Re: **Palomas Peak**
8300 Palomas Ave. NE
Traffic Circulation Layout
Architect's Stamp date 01/15/2021 (D19D031)

Based upon the information provided in your submittal received 1/15/2021, the above referenced plan cannot be approved for Building Permit until the following comments are addressed:

AS101

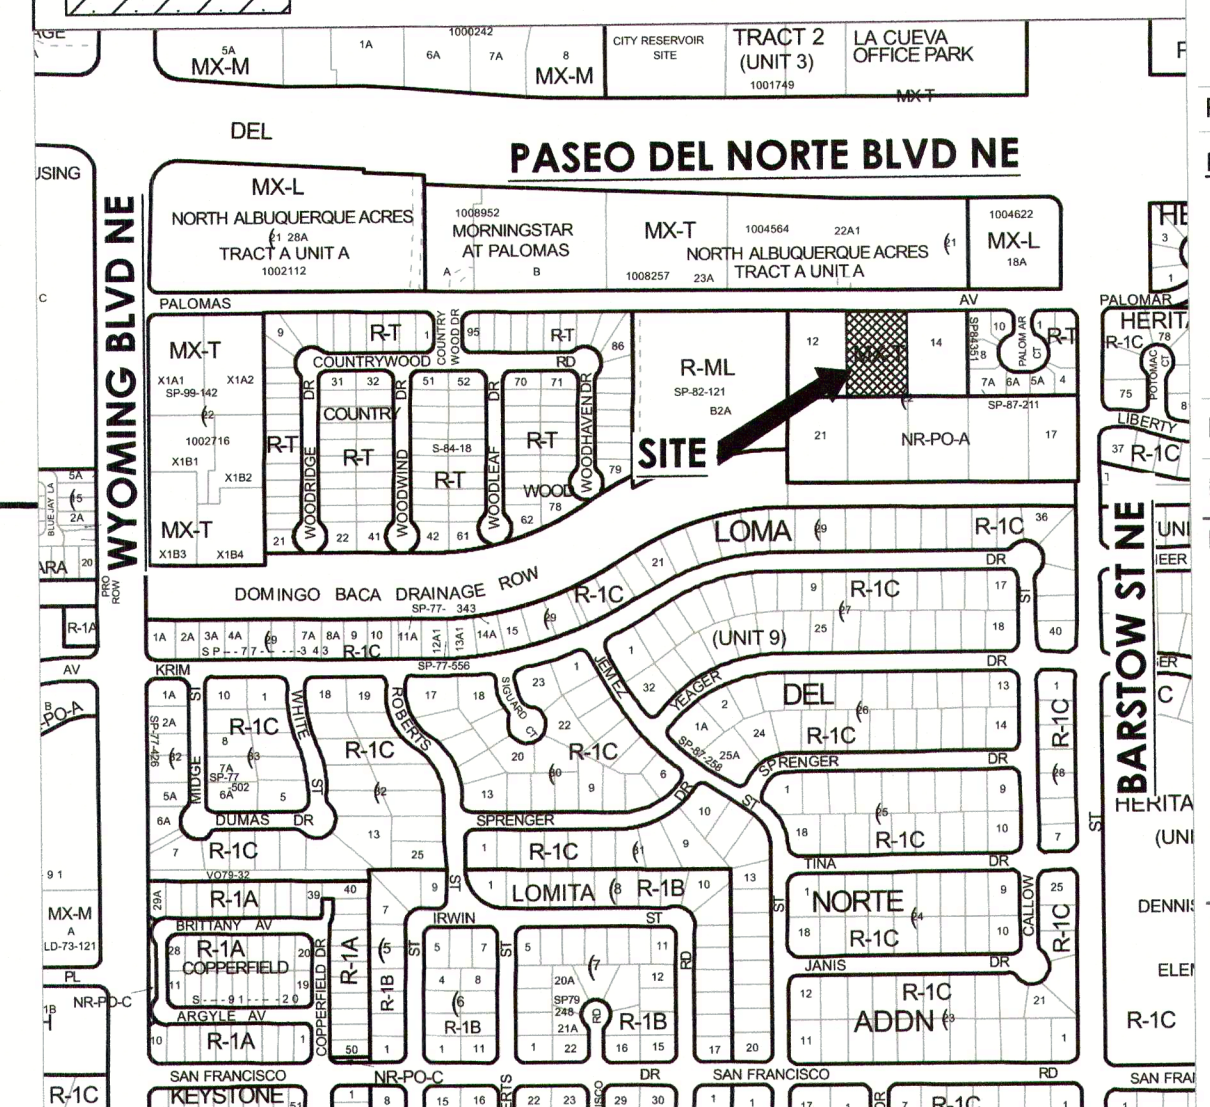
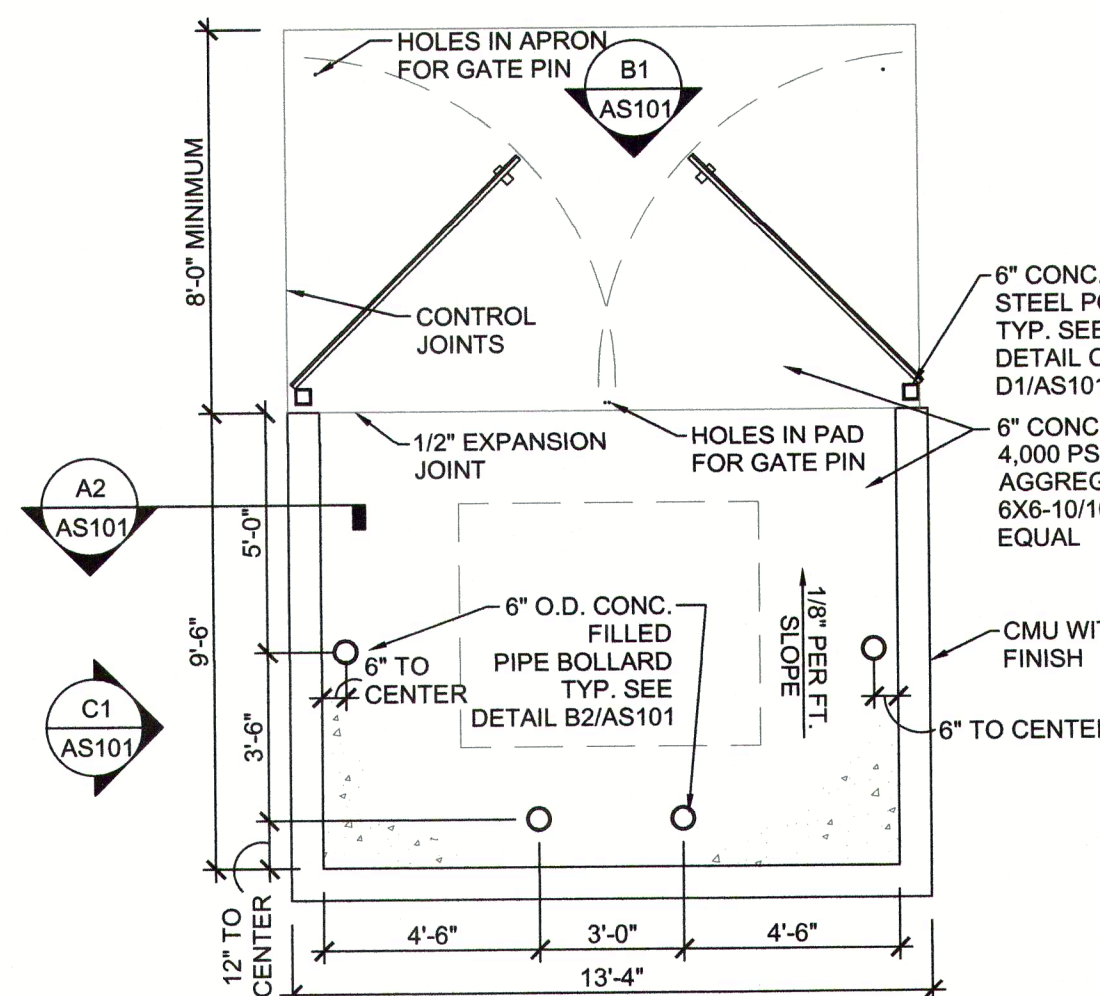
1. Provide a Traffic Scoping Form or approved Traffic Impact Study for the development.
2. Provide shared access agreement for the adjacent property to the east.
3. Routing for refuse and delivery vehicles should be shown on the plans.
4. Fire and emergency access: Provision for access by fire and emergency vehicles needs to be in accordance with the Albuquerque Fire Plan Checking Division. Provide approval from the Fire Marshall.
5. Provide on-street parking approval.
6. Sidewalk in the public right-of-way needs to be at least
7. Increase sidewalk width to 6 feet from public sidewalk to building entrance.
8. Increase sidewalk width to 6 feet from handicap parking to building entrance.
9. Show motorcycle parking sign location.
